**From:** Jean Fraser  
**To:** Tom Greer  
**CC:** Jaegerman, Alex  
**Date:** 10/9/2013 6:15 PM  
**Subject:** 133 York Street- issues that need to be addressed urgently

Today we conducted the first substantive review of the recently submitted Hearing submissions on this project. It appears that there are several fundamental issues that need to be resolved prior to this being considered at a Public Hearing. We are not sure that these can be resolved (with reviewer signoffs) in time for the October 22, 2013 PB Hearing (for which the PB Report is finalized on 10.17.2013) and we strongly advise delaying the Hearing.

10 TREE FILTER DETAILS

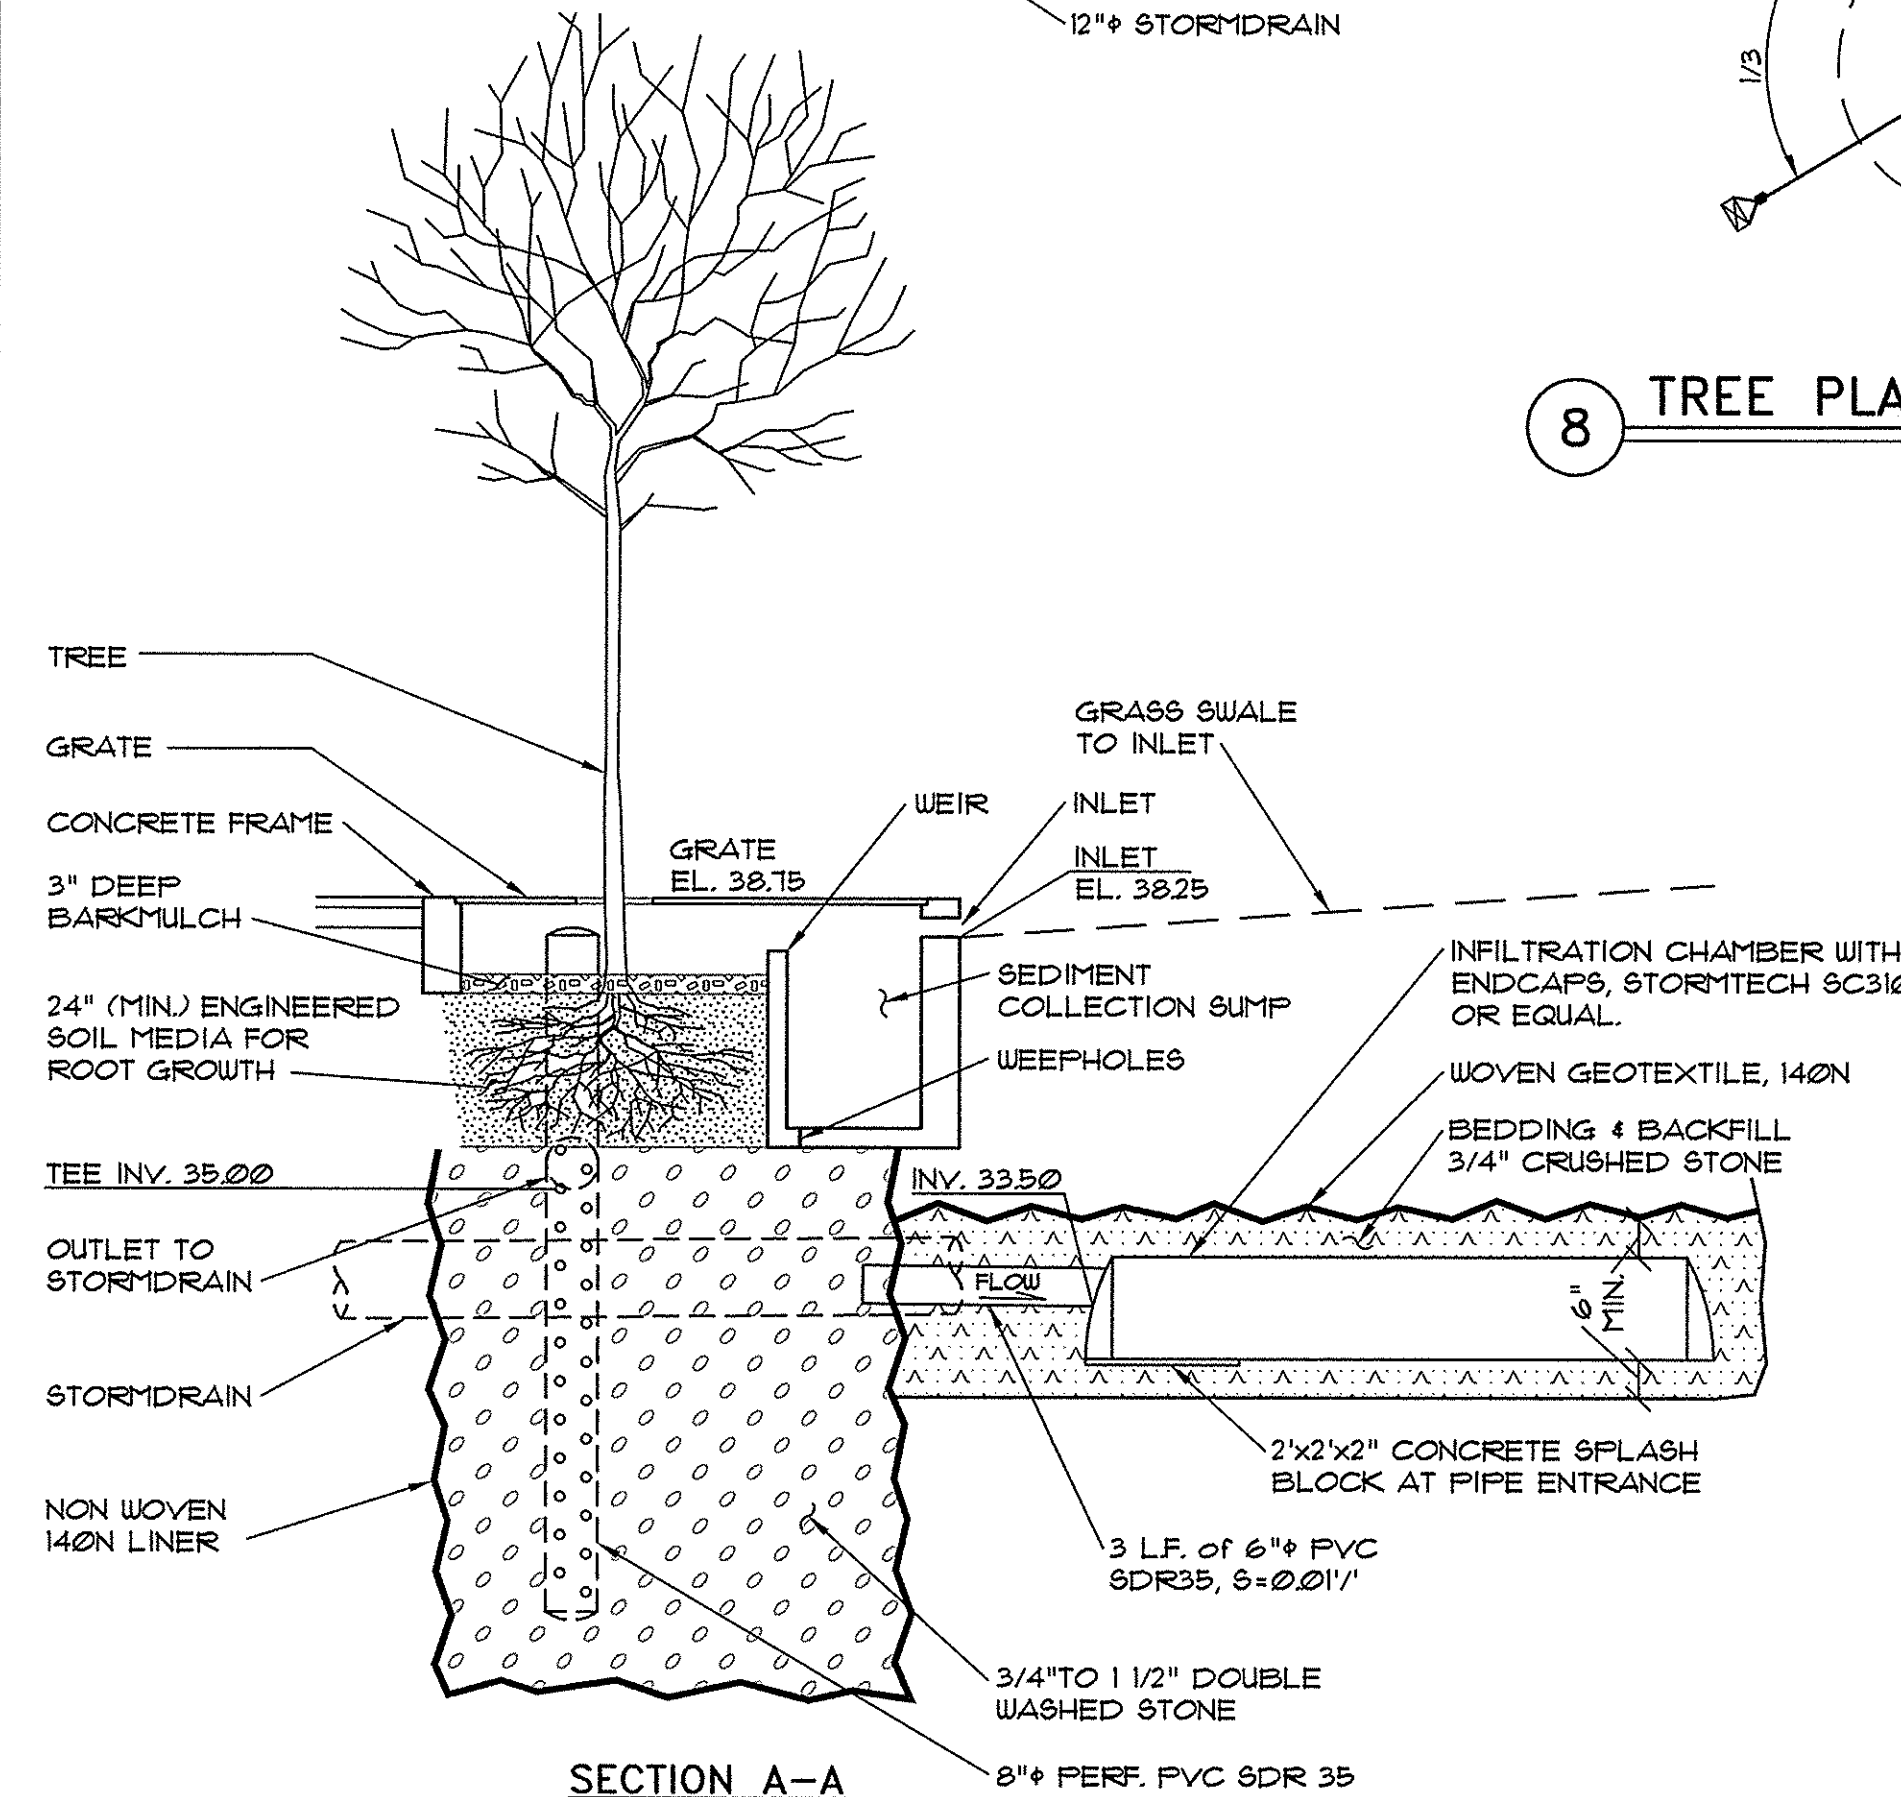
1) *The tree filter sizing calculation indicates that the subsurface soils have an infiltration capacity of 0.525 cubic feet per second over the effective infiltration area. It appears the unit conversion did not account for an hours-to-minutes conversion factor (divide by 60); as such the modeled infiltration rate is significantly higher than could be expected. Please revisit the calculation and model to verify that the tree filter system can provide sufficient infiltration capacity;*

## Passenger Car at 5 mph, Space 1

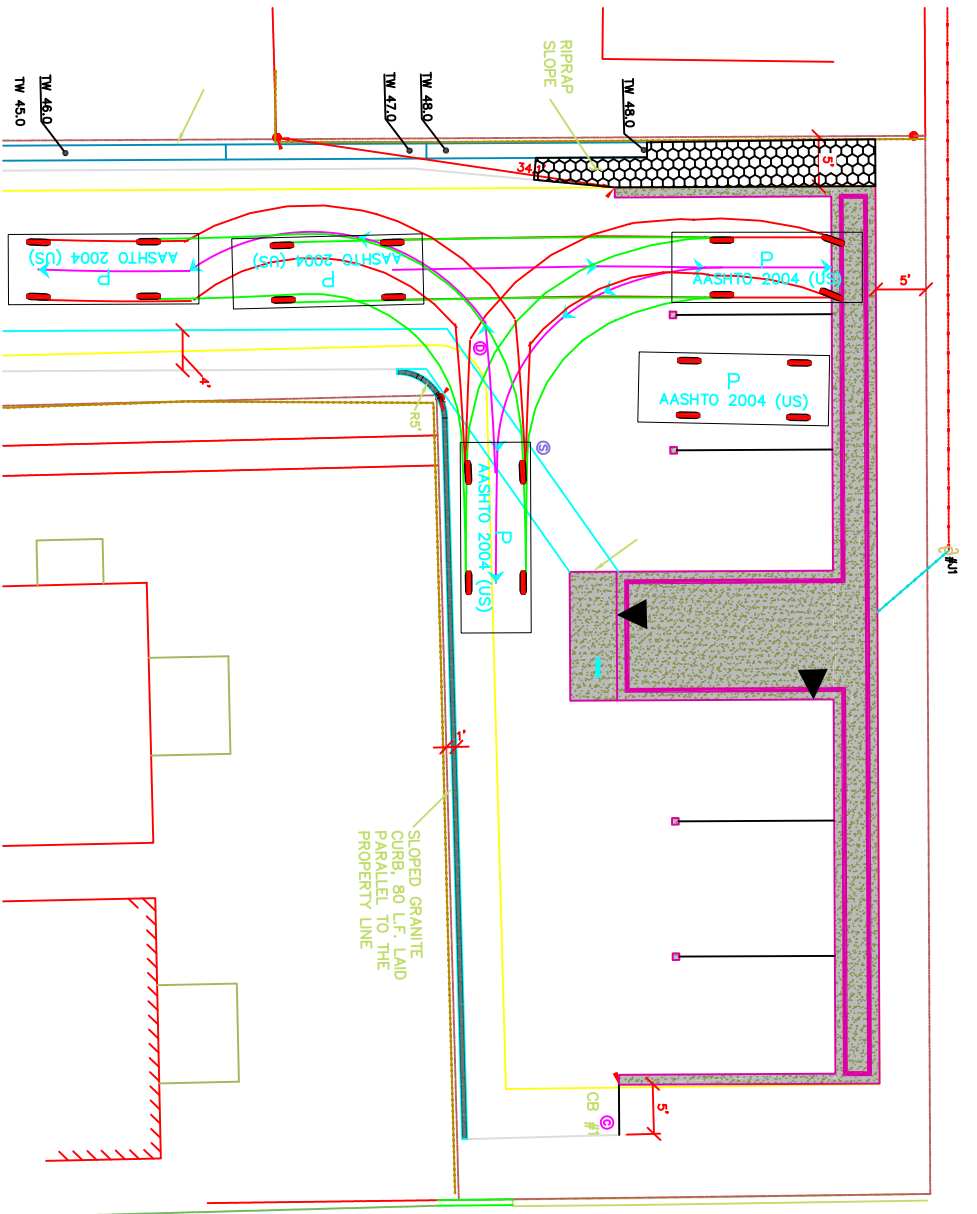
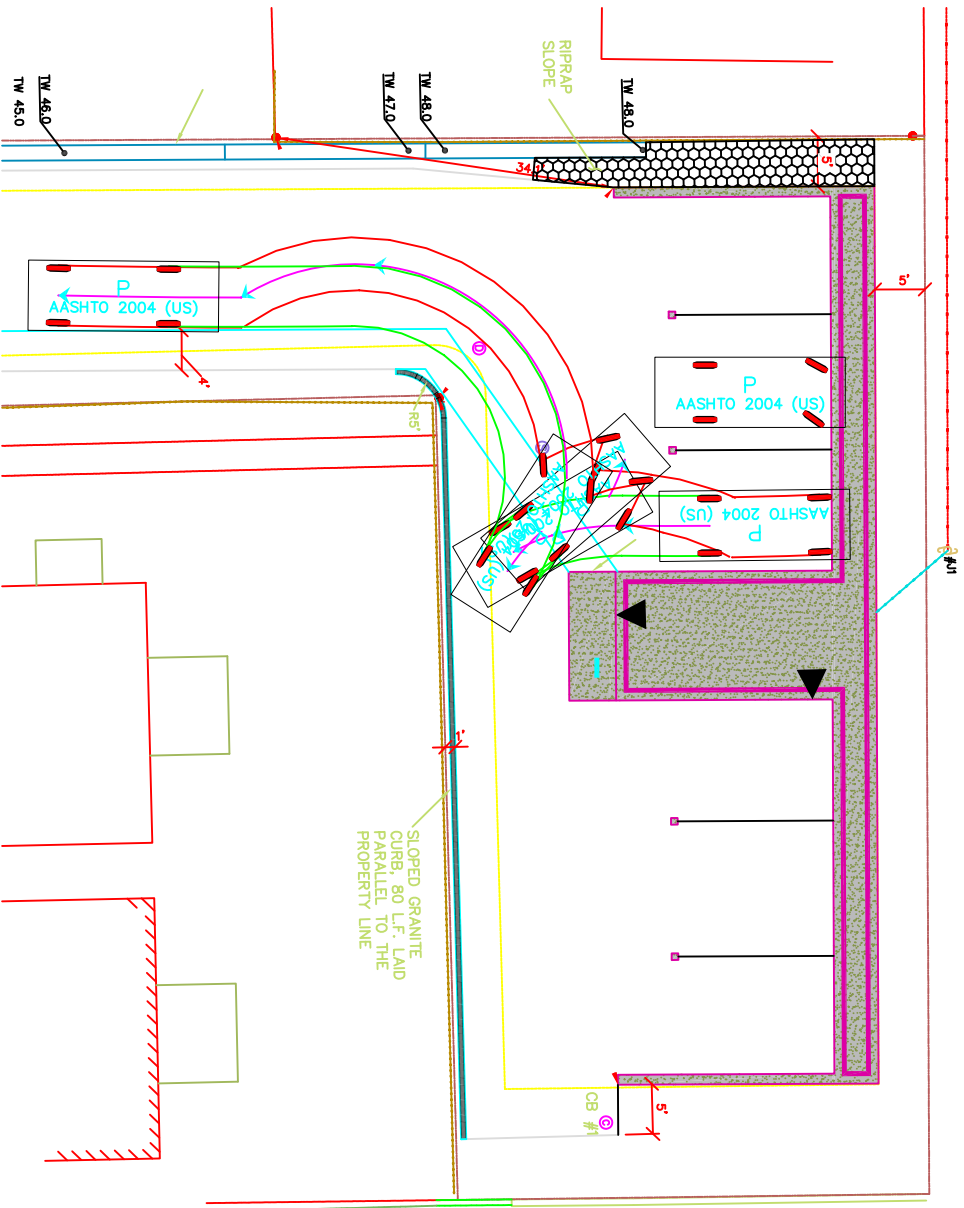
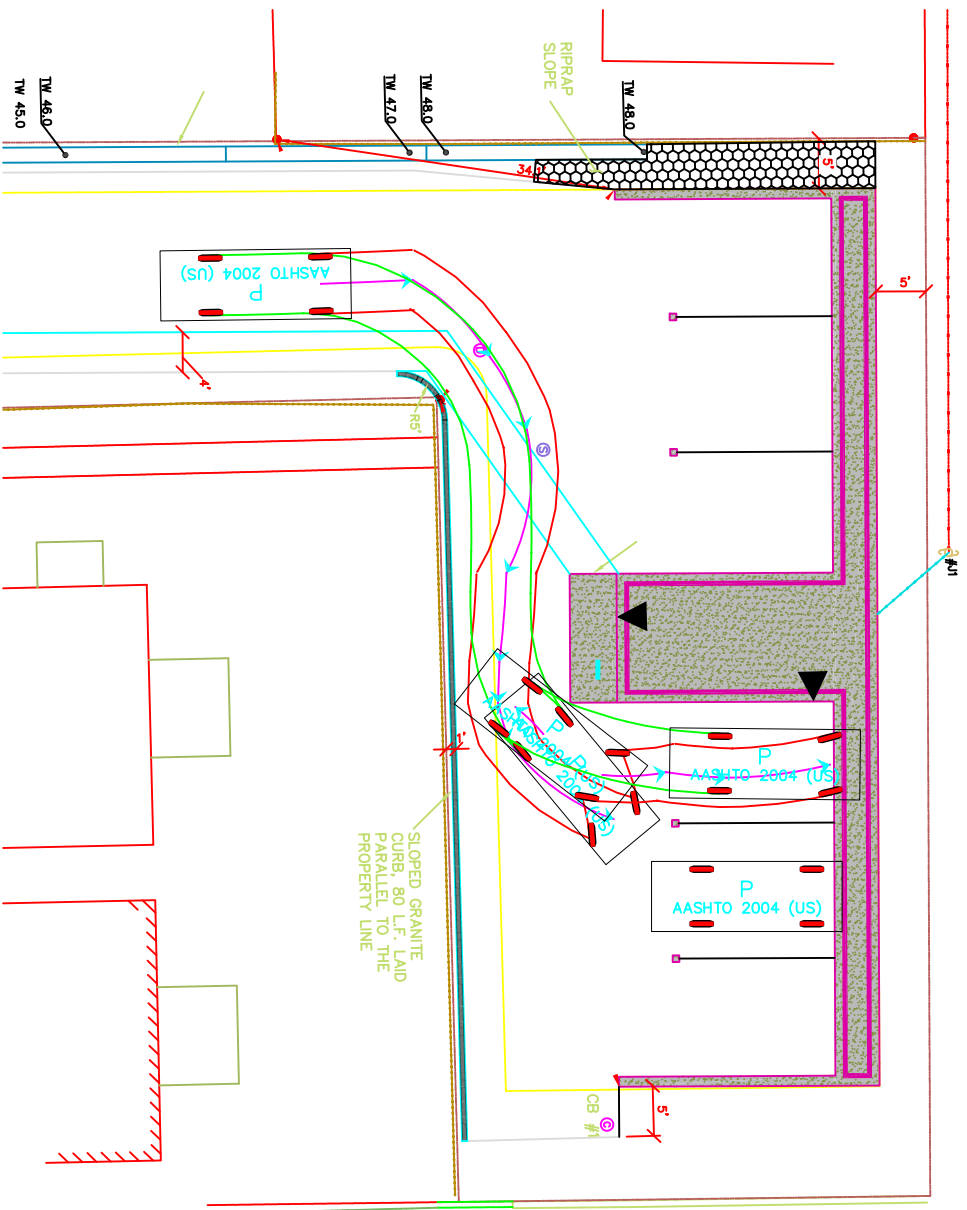
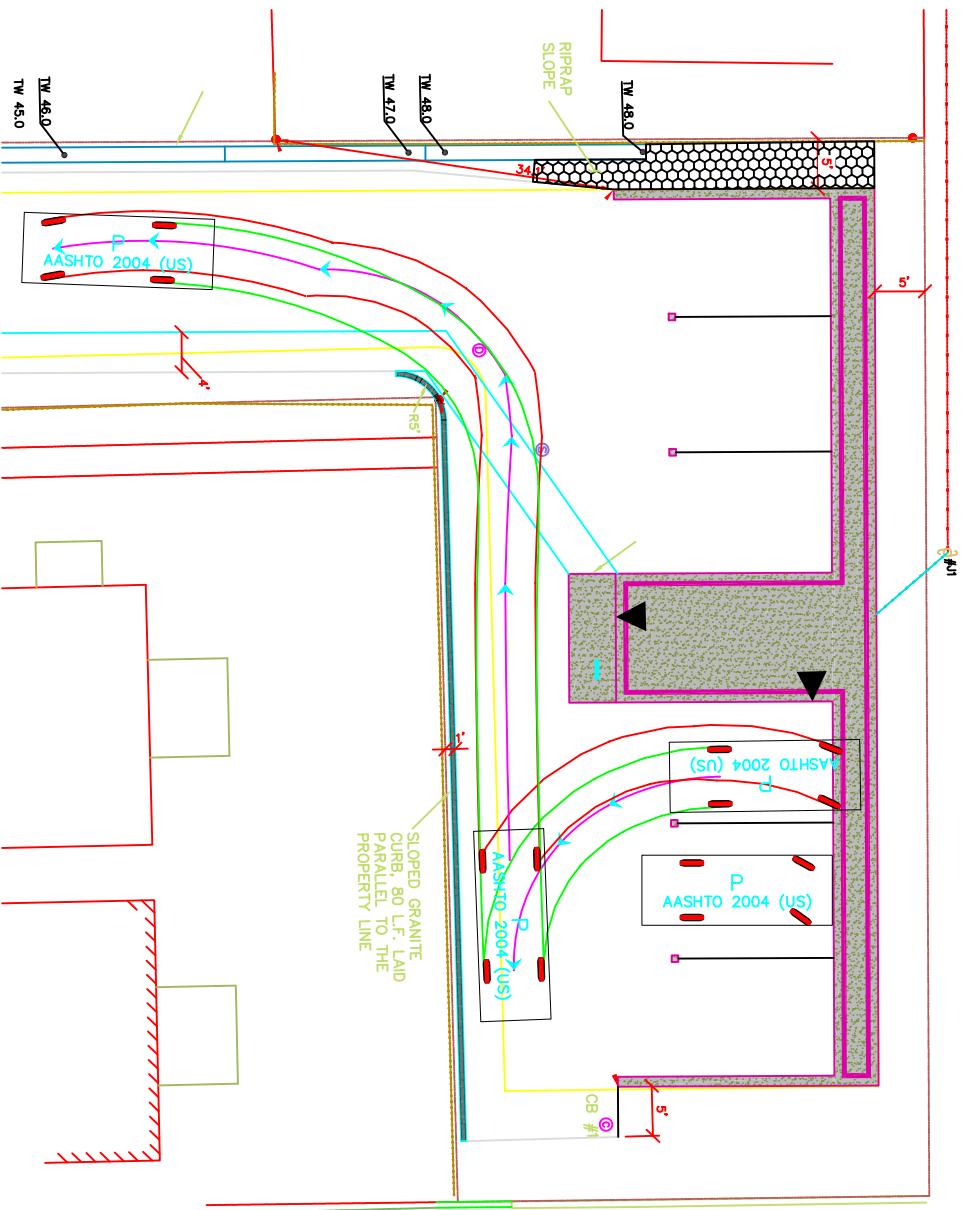
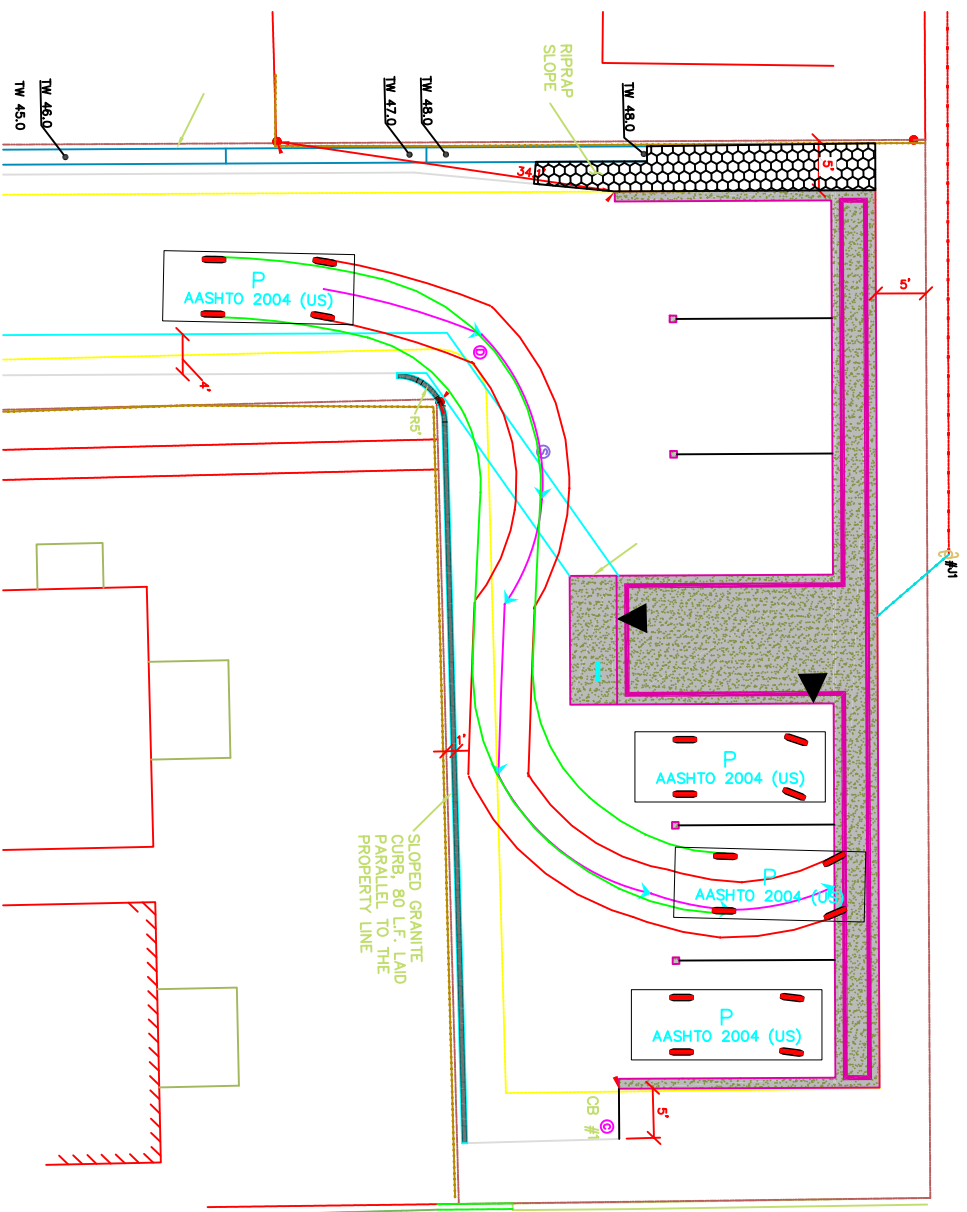
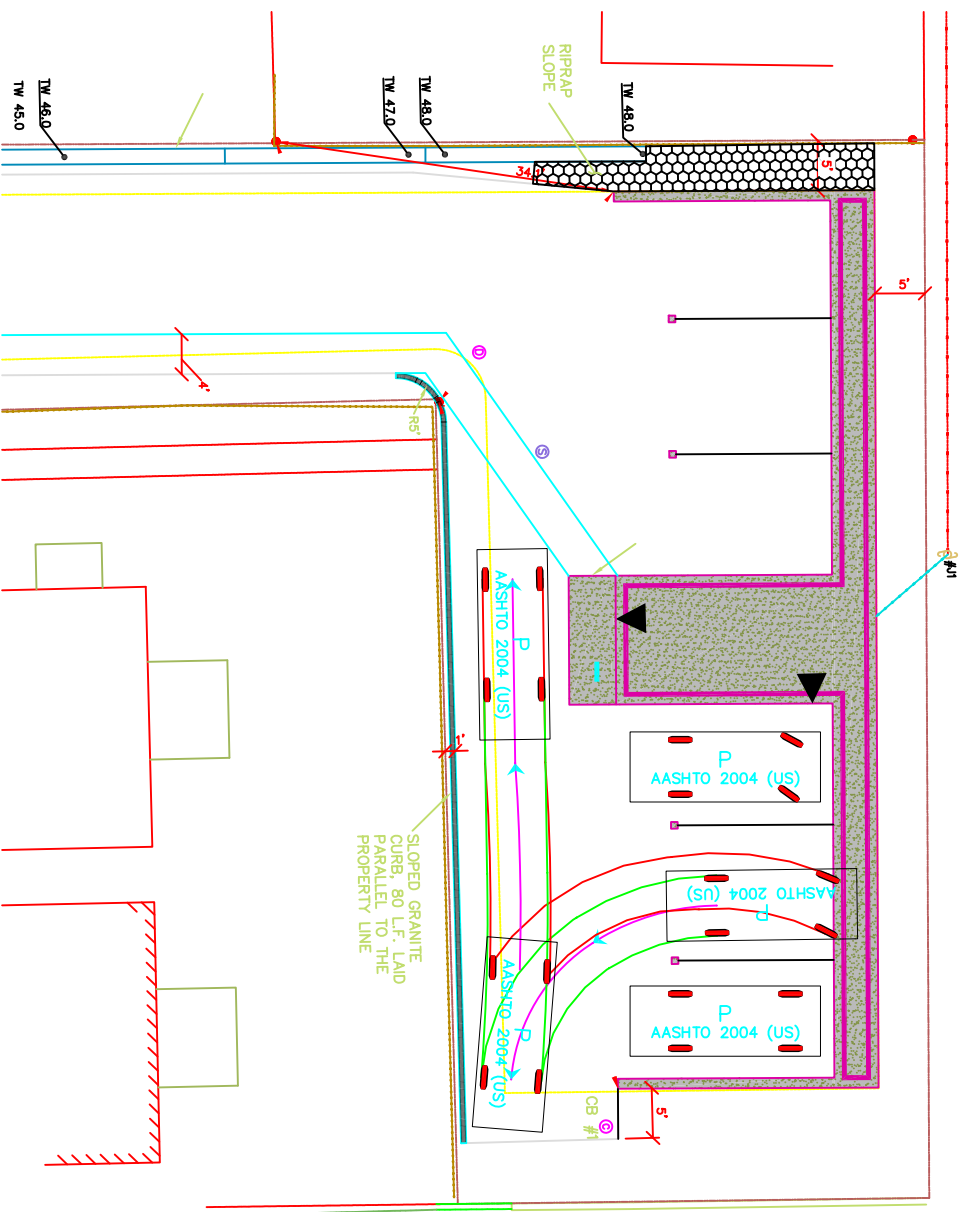
Vehicles are shown parked partially "under" the storage units and starting from that point; yet the storage units are shown on the elevations with full height doors. Even if the storage units are partial as shown in the section, they appear to be 3-4 feet above the ground which is not high enough to allow a car to pull that far into the building;

For at least three of the parking spaces the ability to enter/exit appears to rely on there not being a vehicle parked in the adjoining space;

We note that these templates take no account of snow storage along the edge/end of the drive;

The templates suggest that the footprint of the building may need to be reconsidered;

We would like to see (in order to finalize staff comments) corrected templates for all spaces that accurately depict the location of the car in respect of the storage unit and show cars in the adjacent parking spaces.
